From: Michael Eastham
Sent: 12 September 2018 14:55
To: 'Sam Sykes'
Cc: Chris Barker; Planning.Responses
Subject: FW: P1456 A/38/18/RES - Manor Nursery, High Street, Angmering - Email 2 of 2

Please see below the email from ADC Drainage to the revised layout plan for Manor Nursery (A/38/18/RES).

From: Laura Gibbons
Sent: 12 September 2018 14:51
To: Michael Eastham
Subject: RE: P1456 A/38/18/RES - Manor Nursery, High Street, Angmering - Email 2 of 2

Proposed Surface and Foul Water Drainage Layout

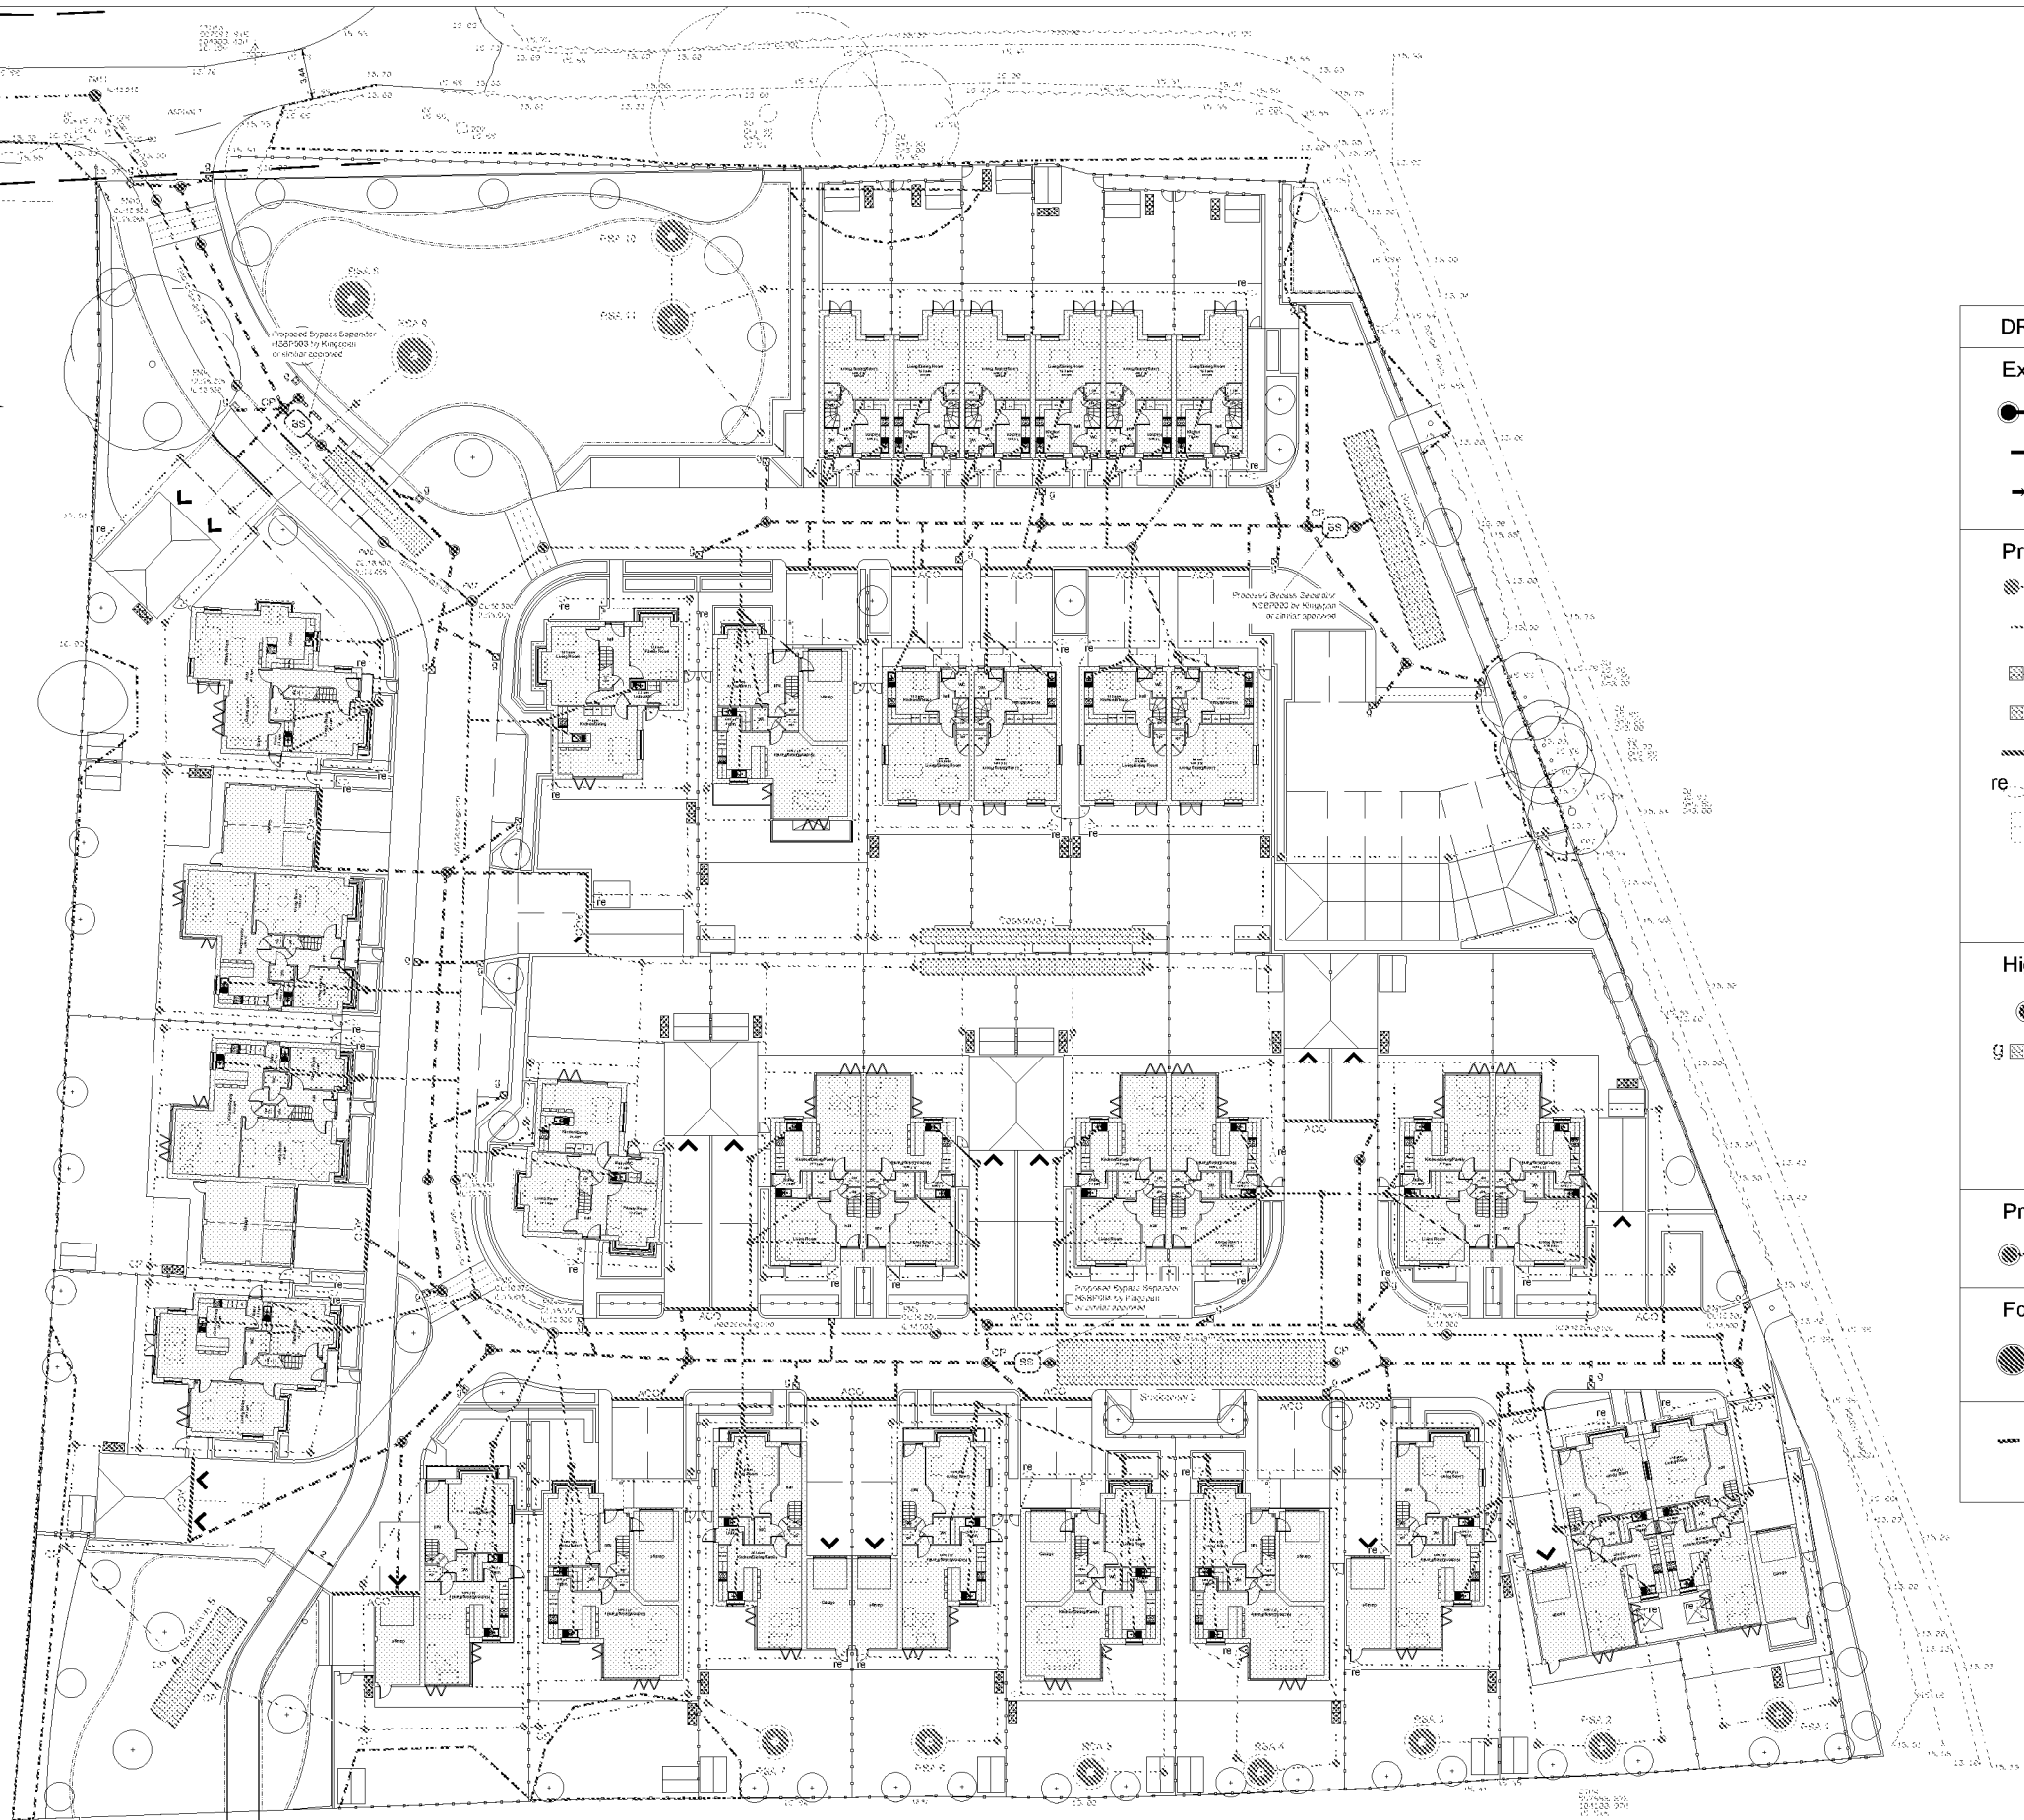
My concerns based on the information provided would be regarding space for SuDS. The site is very crammed in as proposed with no room for open suds features specified. Open features should be incorporated into design to provide sufficient treatment of surface water.

Winter groundwater monitoring (October to March inclusive) will need to be completed and infiltration testing will need to be completed based on these results, i.e. infiltration tests completed above maximum recorded winter groundwater levels. We would like to see permeable paving utilised where possible in addition to other infiltrating suds features if it is found infiltration works.

It would also be good to understand what their plan would be if it is found infiltration does not work.
